DECISION DELEGATED TO HEAD OF PLANNING

Application No: H17-0566-25 **Applicant:** Mr I Bates

Proposal: Demolition of 180 Station Road, associated outbuildings, adjacent shed and erection of 7 two and three bed houses - approved under H17-0130-23. Modification of Condition 2 to allow amendments to previously approved plans and modification of Condition 3 to amend brick type from Vandersanden Bellona to Forterra St Lawrence for all house types.

Location: Land Off Station Road Surfleet Spalding

Proposed Block Plan
Scale 1:200

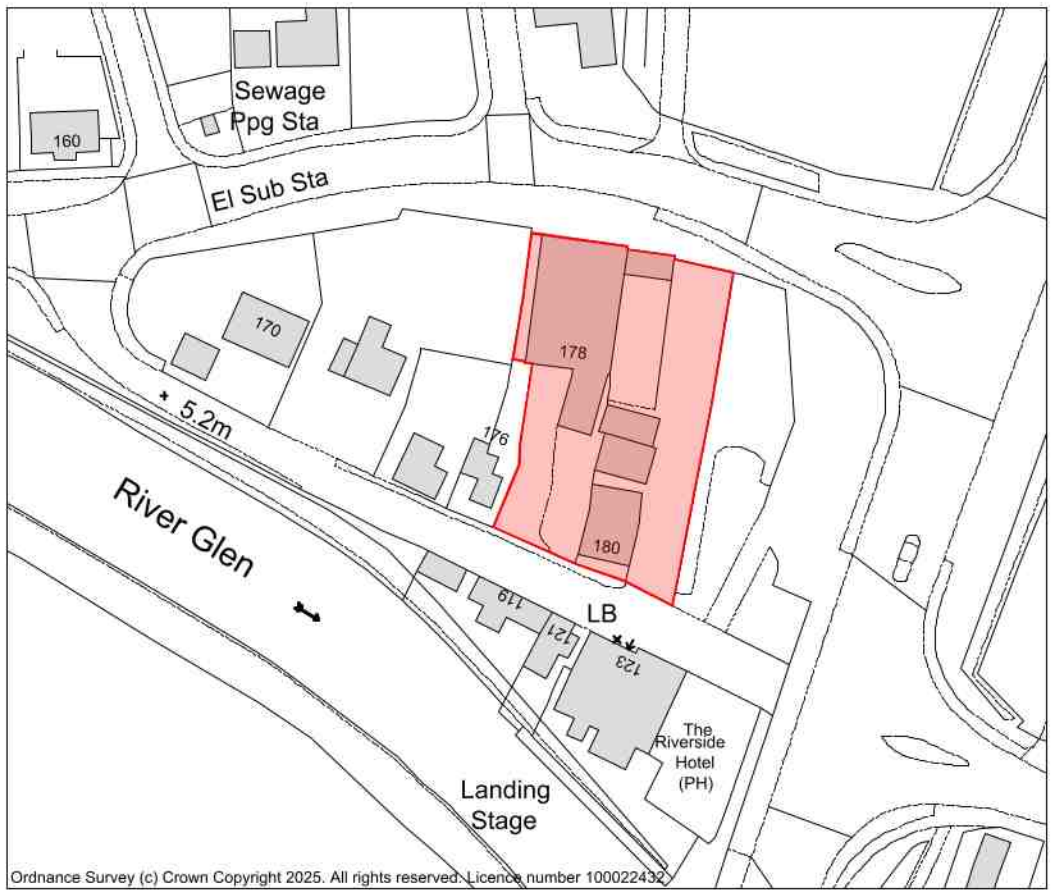
This Section 73 application seeks to vary condition 02 (approved plans) and condition 03 (materials) of planning permission H17-0130-23 to amend the siting of two pairs of semi-detached dwellings, Plots 4 and 5 and Plots 6 and 7. The position of the semi-detached properties will in effect be swapped with Plots 4 and 5 (2-bedroomed houses) sited in the approved position of Plots 6 and 7 (3-bedroomed dwellings) and vice-versa. No change is proposed to Plots 1, 2 and 3.

The frontage development approved facing onto Station Road, Plots 1,2 and 3 will remain unchanged as approved under the original planning permission H17-0130-23. To the rear of the site the position of the two pairs of semi-detached dwellings, Plots 4,5,6 and 7 will be handed, Plots 4 and 5 will be re-positioned adjacent to the eastern boundary of the site in the approved position of Plots 6 and 7 and Plots 6 and 7 will be sited in the approved location of Plots 4 and 5. Visually, the change in the position of the plots to the rear of the site will have limited impact on the wider character and appearance of the area. The house types remain as approved as does the access and parking area. There are no further implications for the use of the public footpath along the eastern boundary of the site and landscaping remains as approved.

The closest residential property to the rear of the site is no.176 Station Road. Plot 7 is positioned beyond the rear elevation and garden area of this dwelling and is located no closer to the site boundary than the extant development. The house types, in terms of design, scale and height remain as approved and in this regard there are no further implications for the level of amenity currently afforded to no.176 Station Road and other neighbouring dwellings in terms of loss of light, overlooking, or creating an overbearing or enclosing impact.
